Our Ref: EN020028

Date: 18 November 2024

Application by Morgan Offshore Wind Limited and Morecambe Offshore Windfarm Limited for an Order Granting Development Consent for the Morgan and Morecambe Offshore Wind Farms Transmission Assets project

Advice following issue of decision to accept the application for examination

Drawing Number:
BP-GBR-MORG-REG-0184

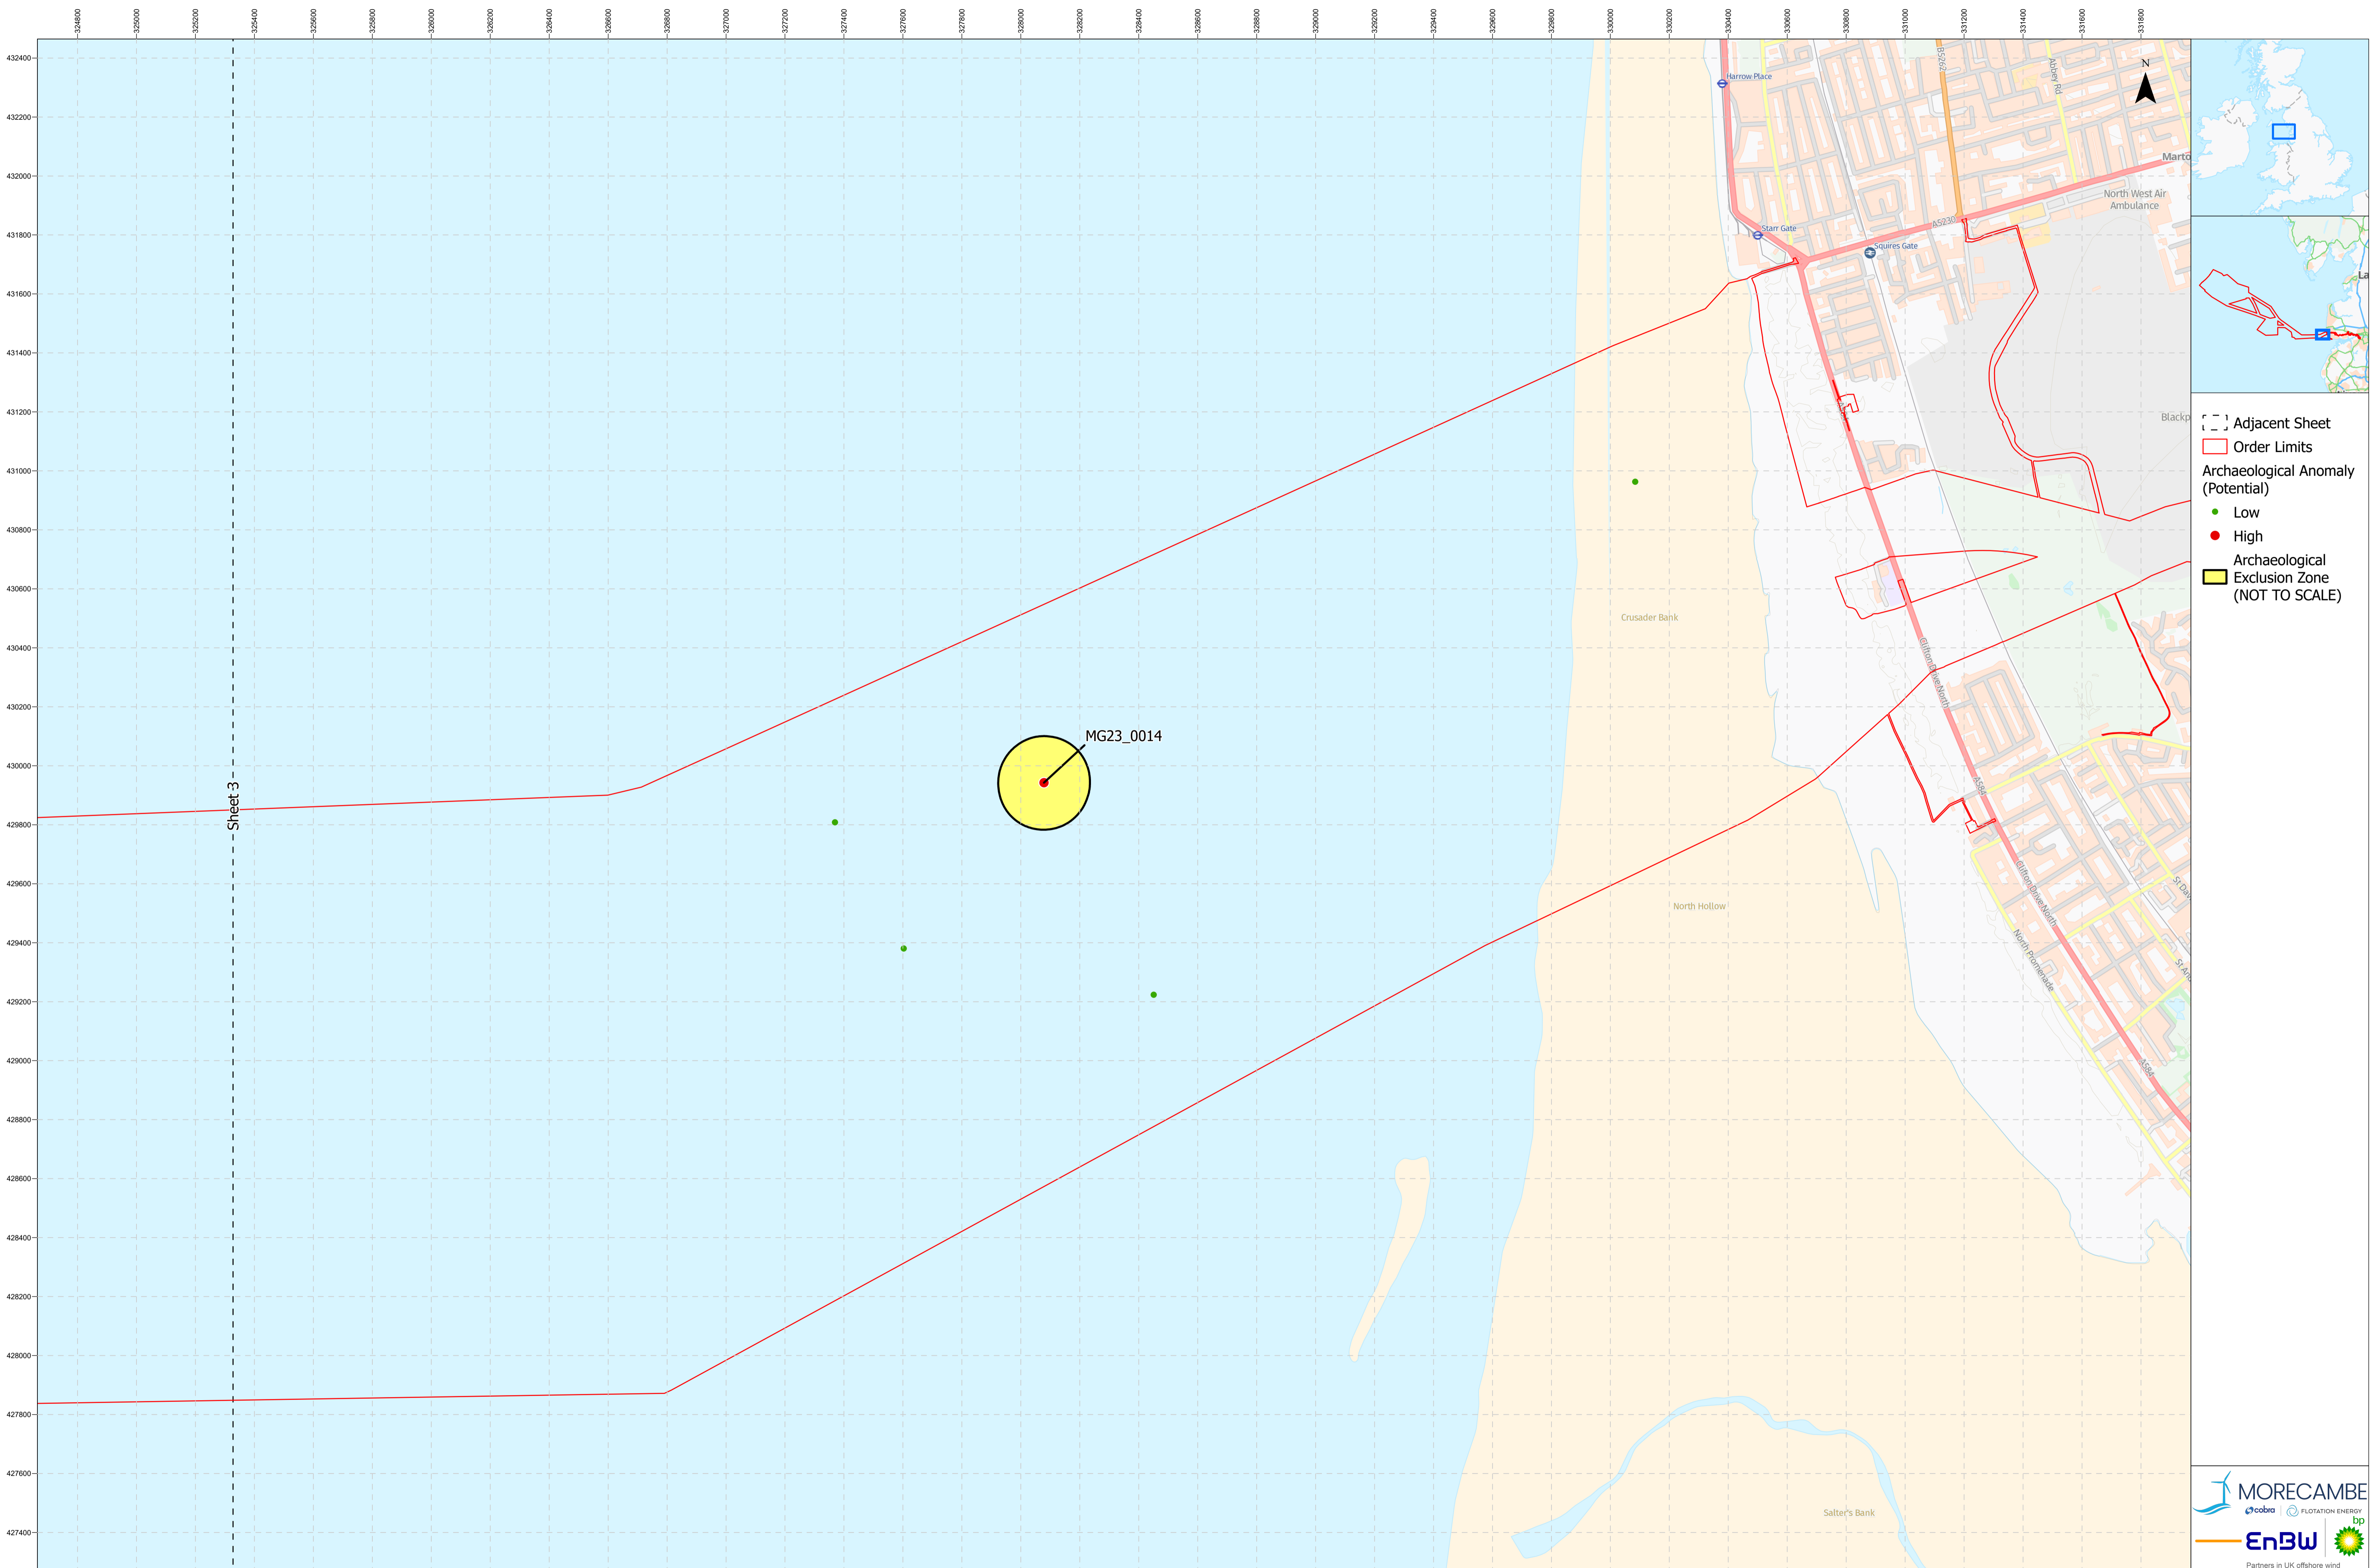
Standalone figure B17 (Statutory and Non-Statutory Features of (The Offshore) Historic Environment Plan) only shows offshore exclusion areas rather than specific features, however the specific sites are shown on the ES figures. The Applicants are advised to provide an updated set of figures with appropriate labelling of the features being represented.
